Application No: Y/84/21/HH
Site Address: 5 Hobbs Court, The Potting Barn Bilsham Road Yapton BN18 0JY
Description of works: Installation of 1.8m timber fence and gate and infill of existing dummy door and panelling under window. This application may affect the setting of listed buildings.

Thank you for your internet representation made on 18th August 2021 which has been recorded as an objection with the comments as follows:

PROJECT	THE POTTING BARN HOBBS COURT, BILSHAM ROAD YAPTON BN18 0JY		
DRAWING	HOUSE PLAN PROPOSED BOARDERED FENCE		
Date	June 2021	Drawn By	PJC
Scale	1: 100 @A3	Iss. App. By	DKC
Drawing No	023 A	File Location	0221

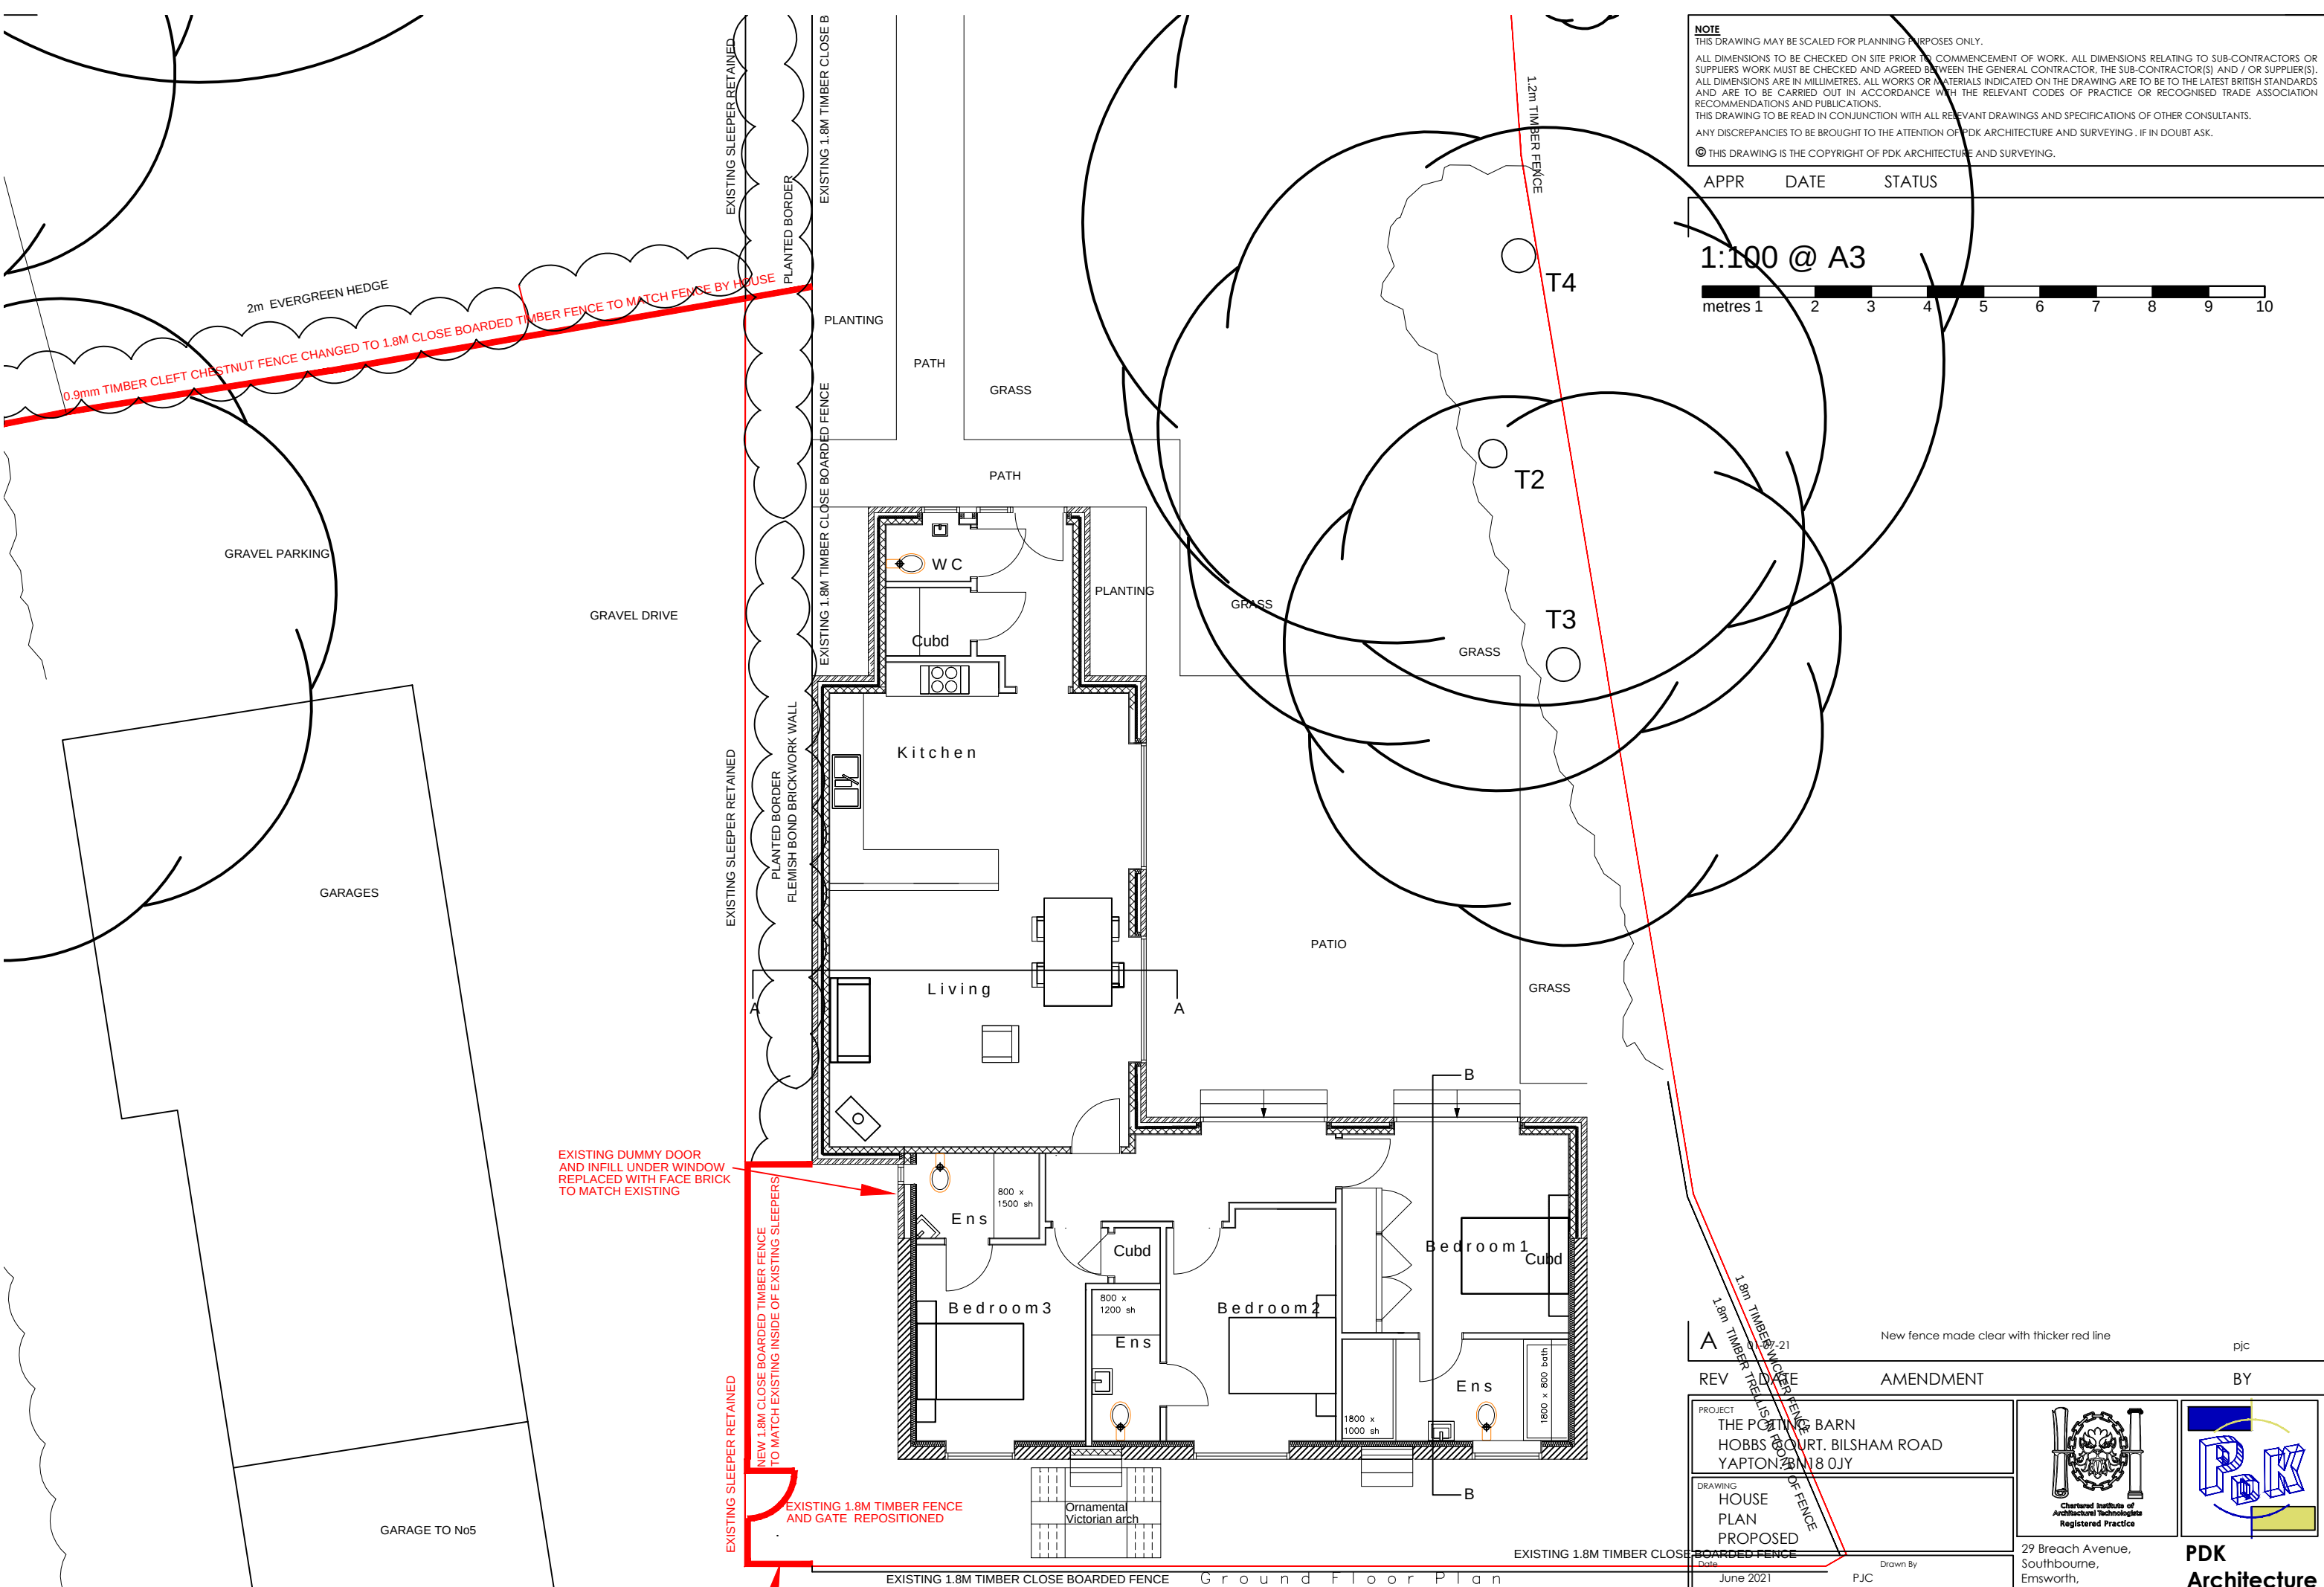
I have seen email correspondence from the applicant's architect dated 06 July 2021 saying he did not understand my objection. If I may clarify, the small area (a metre or so) on the South Side of the fenced area as it meets my property, will be of a different construction to the rest of the fencing (my fencing) at the same elevation, albeit inside the sleeper line. I just think it will be visually more in keeping if that small section was of a similar construction to my fencing on that elevation. As previously advised, whilst the applicant did send me updated drawings (there were errors on the initial drawings) she would not meet with me to discuss my concerns, which is possibly why there is some confusion. I would appreciate it if my concerns were addressed.
